V1_Site Plan Drawing_COMMENTS.pdf Markup Summary

DEVELOPMENT PLAN

ACTION EXCAVATING STORAGE UNIT SITE
 3511 WEST COLORADO AVENUE
 EL PASO COUNTY, COLORADO

COUNTY PLANNING FILE NO.: BOA-263

DEVELOPMENT PLAN

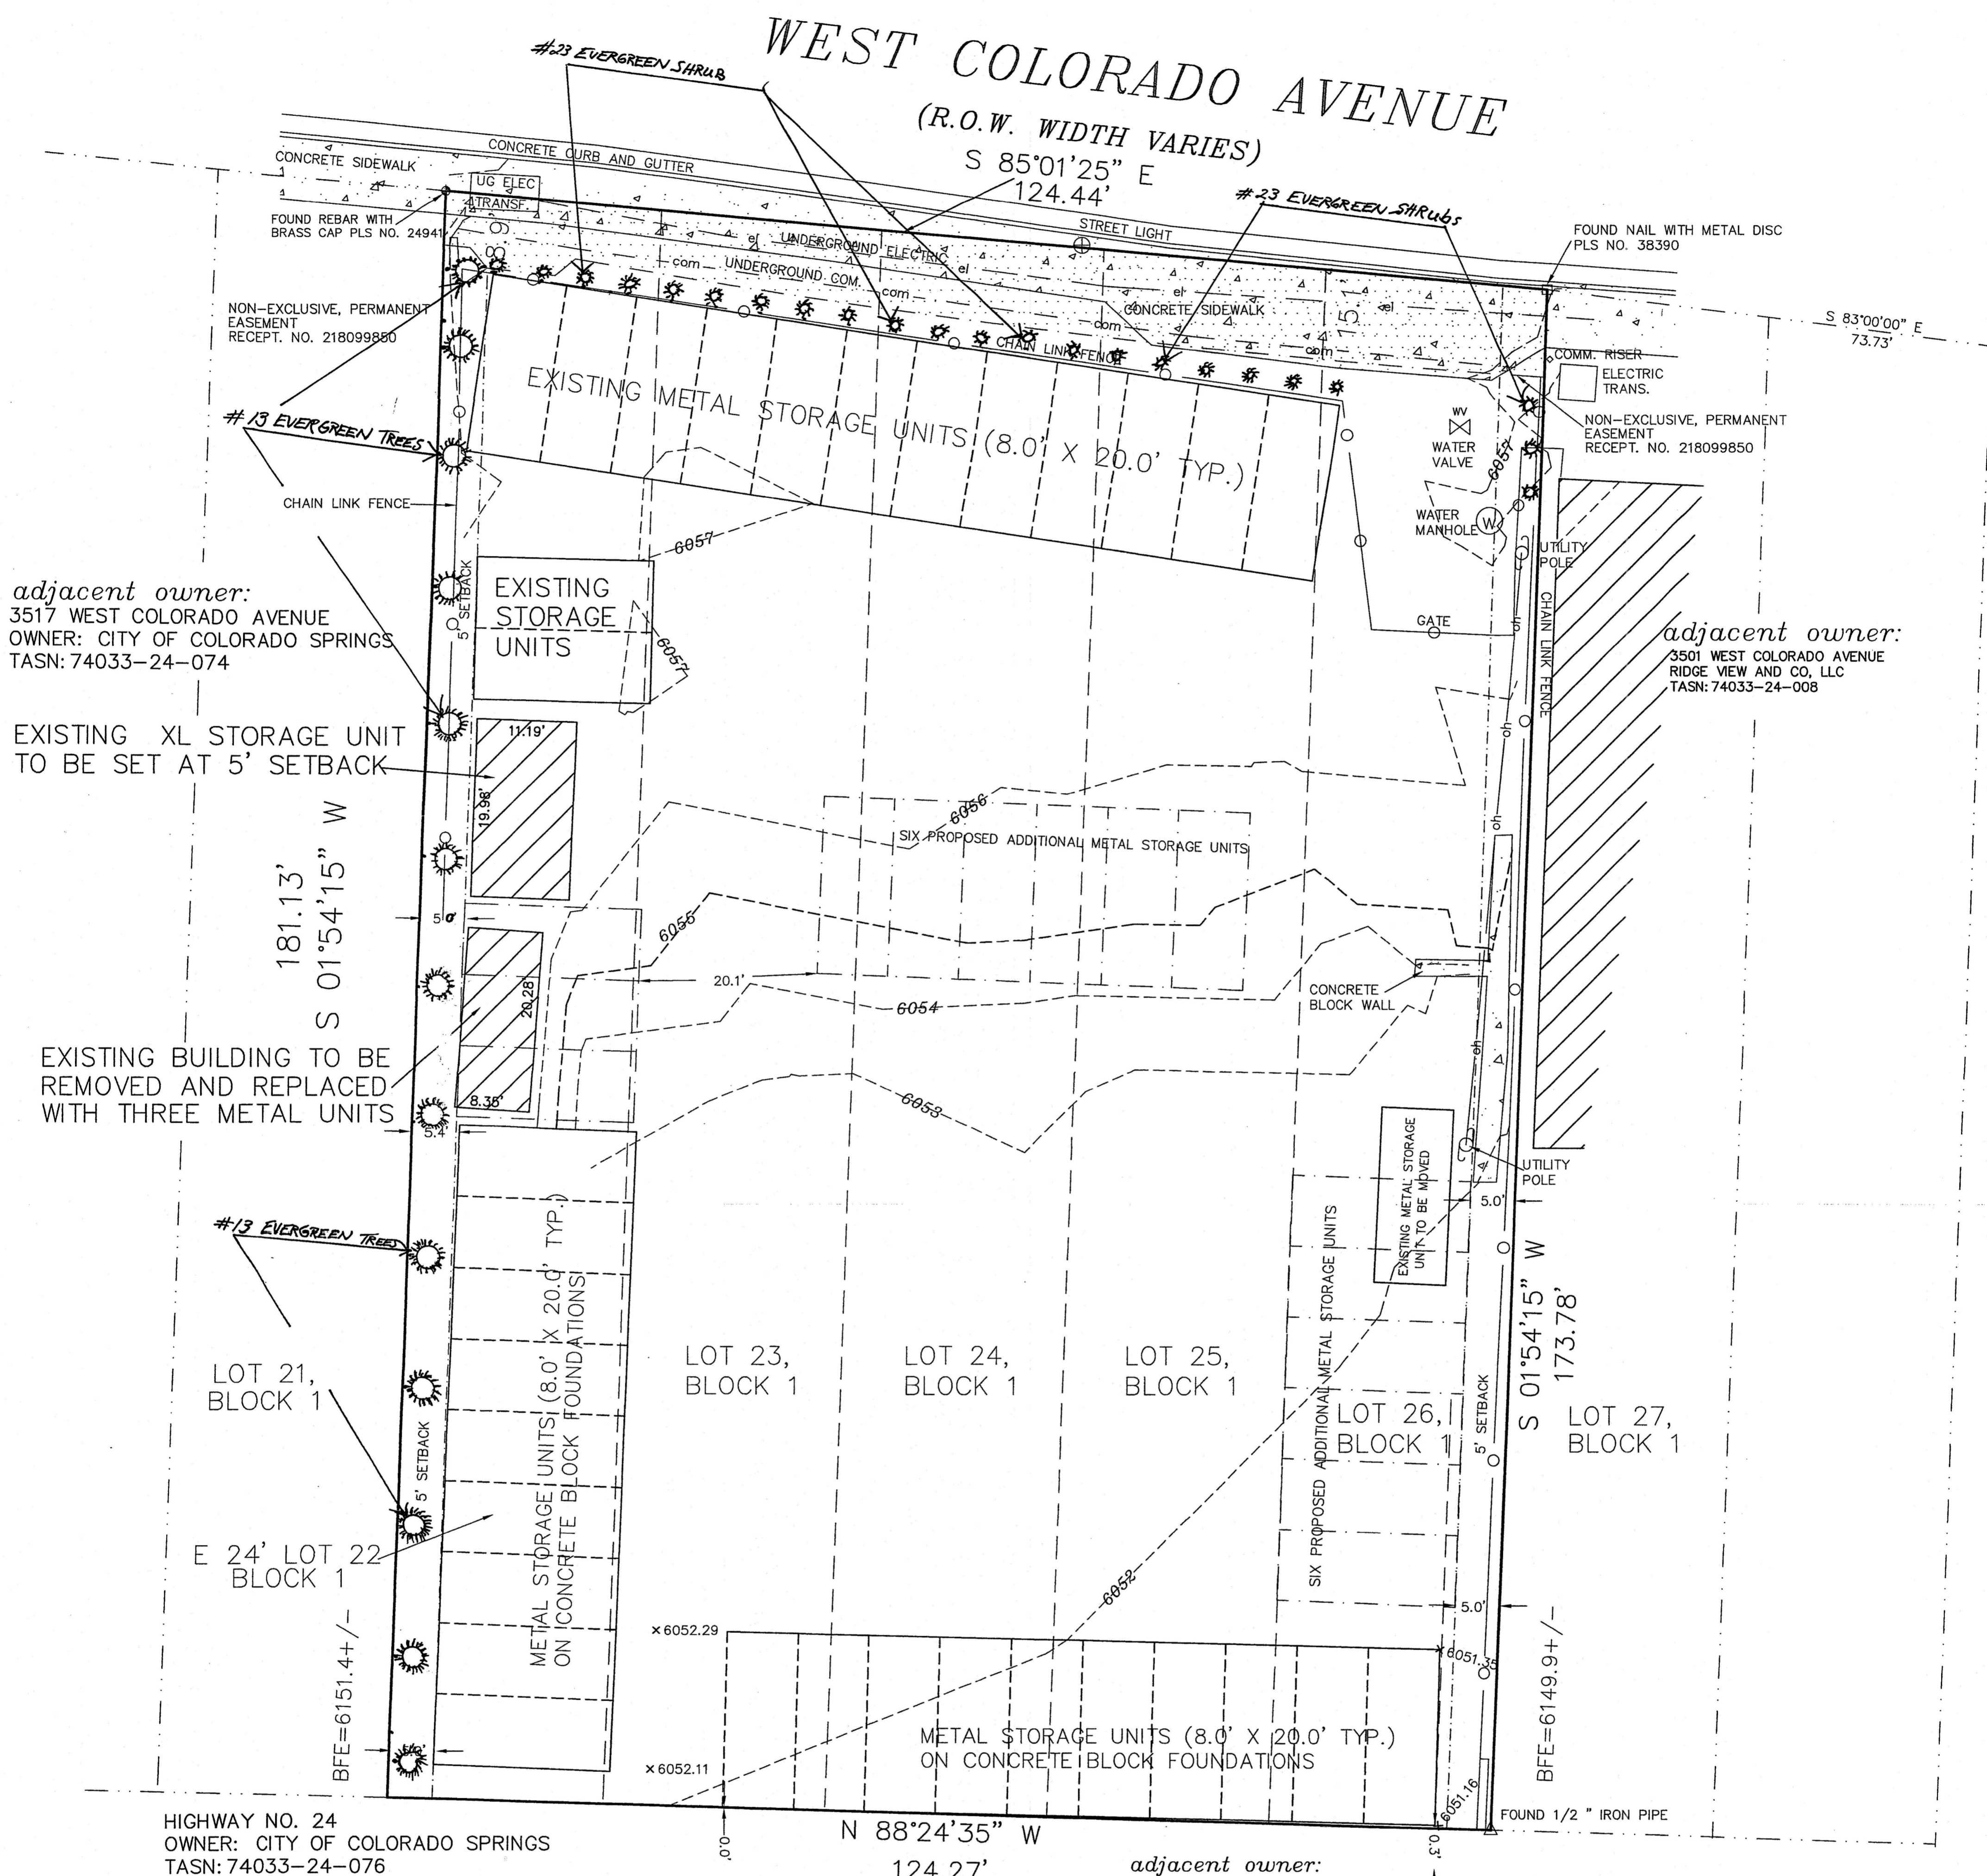
Include Label: City owned and maintained

Additional access comments will be provided with the subsequent site development plan. This access width does not appear sufficient to support 2 way commercial traffic. The minimum required width in the ECM is 25'.

Delineate and label the ground surface within the property (asphalt, dirt, etc.)

Label traffic circulation on site including all points of ingress/egress on the property.

In addition to labeling the base flood elevation, please show floodplain on the site plan.

A portion of the site is located within the 100-year floodplain, based upon review of the FEMA FIRM. The flood map for the selected area is number 08041C0707G, effective on 12/7/2018. Revise statement.

Verify that your contour labels/spot elevations are correct. They are currently labeled 100' below BFE. Revise accordingly.

Label as existing or proposed so it is clear

Are these existing or proposed? It is unclear with the conflicting labels

Identify this distance measurement.

Identify this distance measurement. This appears to be within your proposed 5' setback.

I can't tell where this easement is located. There does not appear to be an arrow. Please clearly identify the location of this easement.

NOTE: If the structures are within this easement, you will need a letter from the easement holder verifying the encroachment will not cause an issue.

Mr. Wyatt mentioned in the PCD office that he would no longer be proposing units within the interior of the lot. This is also mentioned in the LOI. Please provide the updated layout.

"SITE PLAN"
This document serves as the Dimensional Variance Site Plan. A full Site Development Plan project is required separately. To avoid confusion, please correct this title.

A "Caretaker's Quarters" unit is an allowed accessory use in this zoning district. However, this is not clearly identified on the site plan. Please label this structure on the site plan.

You identified truck/U-Haul driving access as a primary reason for the need to maintain the shipping containers' current configuration. Please label driving aisles and driving widths within the property to support this!

Number and label the dimensions of each unit or provide one depiction of the typical "(TYP.)" on a second sheet or in the legend area so that you can label each storage unit as "Unit 1 (TYP.) Existing", "Unit 2 (TYP.) Proposed", "Unit 3 (TYP.) Existing, will be moved to meet 5' setback", etc. Include the height of the units.

Mini-Storage has a minimum parking space requirement of 1 standard space for every 100 units plus one space per employee. The minimum parking requirement will be 1 customer parking and 1 employee parking (total 2 standard spaces), plus 1 ADA van accessible space. (3 total) Show this on the site plan and include this detail in the summary area. Dimensions need to be shown.

The dimensional standards for CS are those identified in the Code. You need to include a separate section below with "REQUESTED DIMENSIONAL STANDARDS" and those should match what is requested in the Letter of Intent and shown on the site plan.

The dumpster on the property needs to be identified on the site plan. Screening of all trash receptacles is required. (fencing, wall, or landscaping) See 6.2.2.G.1.b - email will be resent.

Wall height needs to be identified.

Add the other required landscaping standards vs. request

How many are currently existing?

How many are proposed?

Height and % opacity must be identified for all fencing.
